Submission Form

Epping to Thornleigh Third Track Proposal. Application number SSI 5132.

Name(s): DARYL WATSON

Figure S.6 Cross-section and elevation - New Cheltenham Station concourse building (see also S.5 for artist's impression)

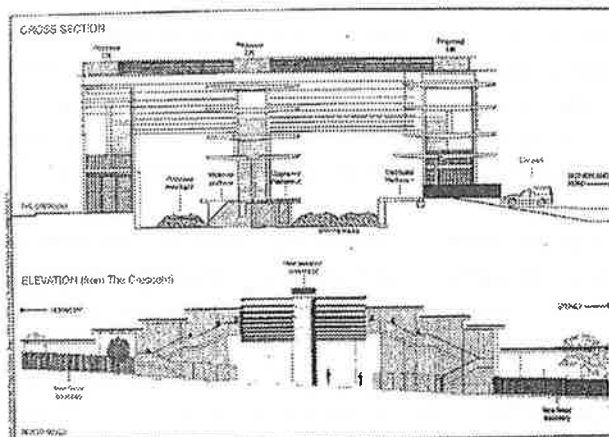
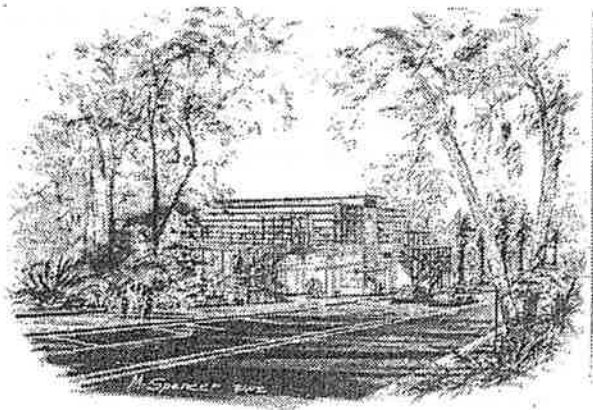
- The proposed redevelopment of Cheltenham Station shows no regard for the HCA. The visual impact of the proposed 13m high glass and steel concourse is totally unacceptable in this HCA.

Figure 5.3 Future Cheltenham Station layout

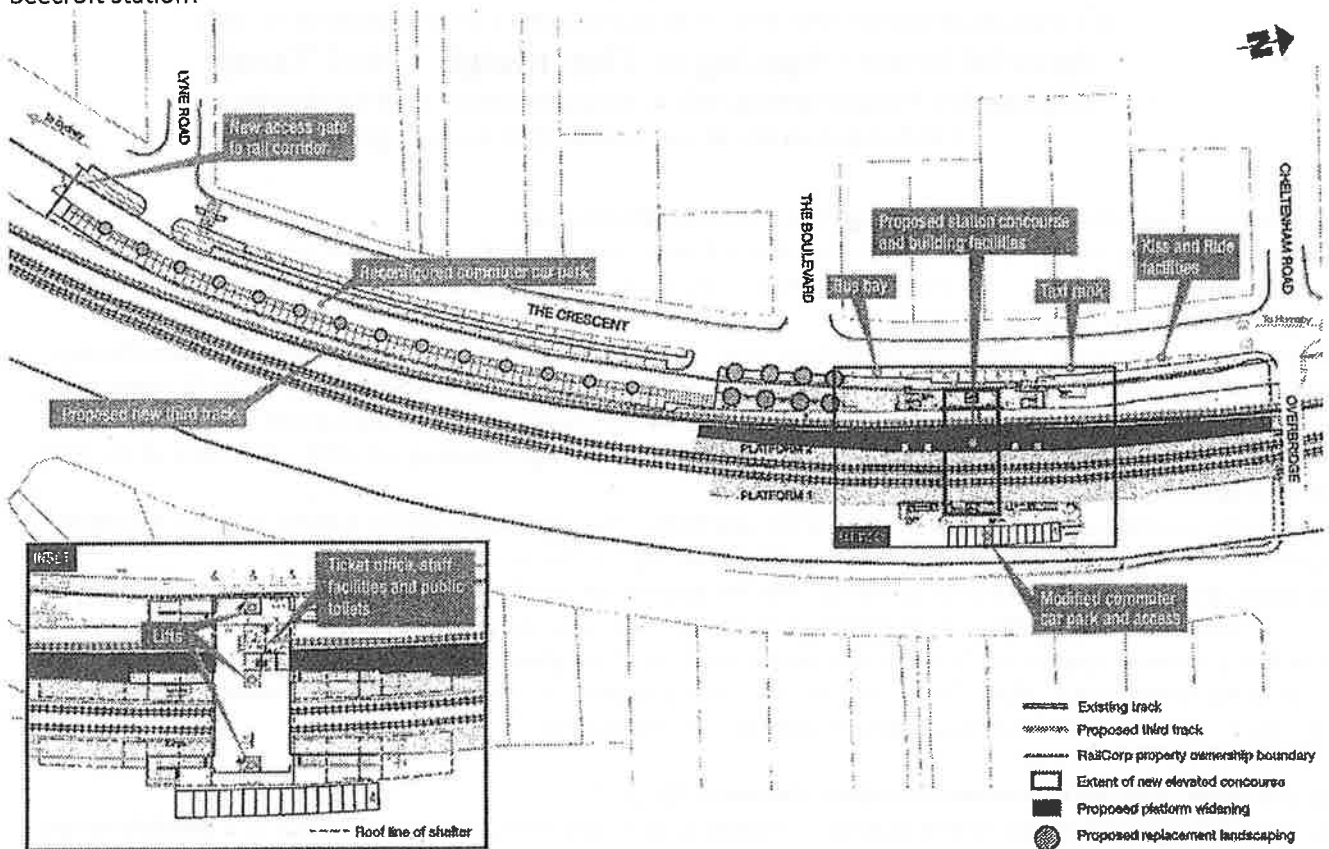
- There has been inadequate assessment of the project's impact on the fabric of the Beecroft Cheltenham Heritage Conservation Area (HCA).
- The plan given for Beecroft Railway station Precinct is vague. The relationship to the trees, playground and original 1895 platform located south of the present station is not shown. A fourth track is shown on the eastern side. The plan does not include urgently needed lifts to allow disabled access at Beecroft Station.
